Please ask for: Ms Iqraa Malik
Email: iqraa.malik@terraquest.co.uk
Telephone: 0121 234 1390
Our Ref: A/39/25/HH
Your Ref:
Date: 10th March 2025

Application for Planning Permission for Works or Extension to a Dwelling

Development: Erection of a 2 storey side extension.
Location: Field House The Thatchway Angmering BN16 4HJ

Drawing: LOCATION/BLOCK PLANS

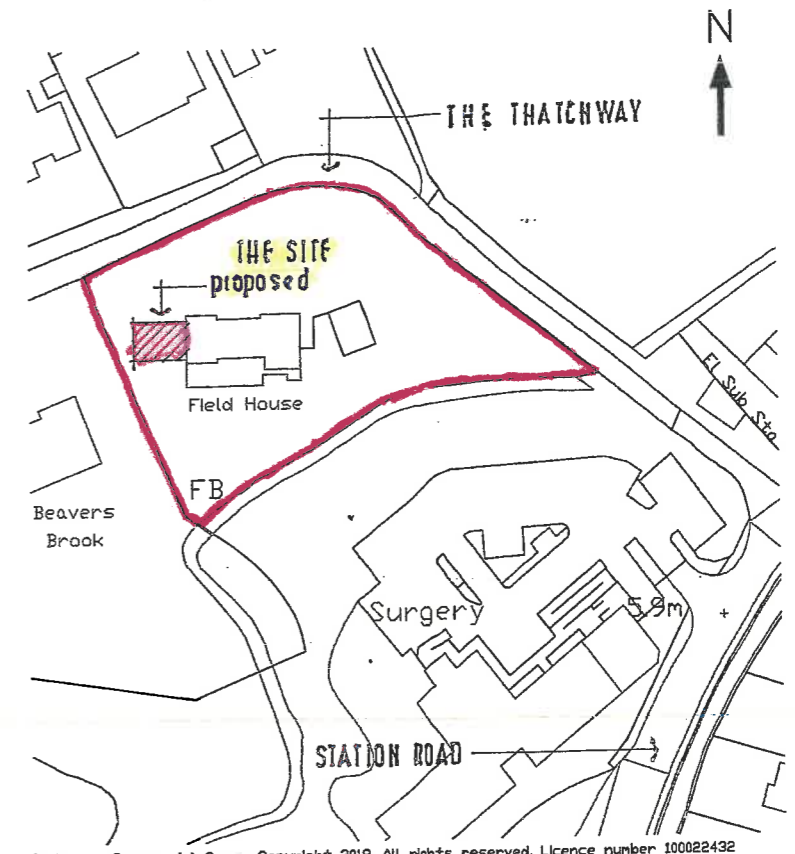
Location Plan Insufficient

The location plan requires a solid red outline around the site boundary, please review and amend.

Block Plan

You are required to have dimensions from the proposed extension(s) to all site boundaries. Please amend. Further details of what must be included on the plan can be found in the Validation Requirements List.
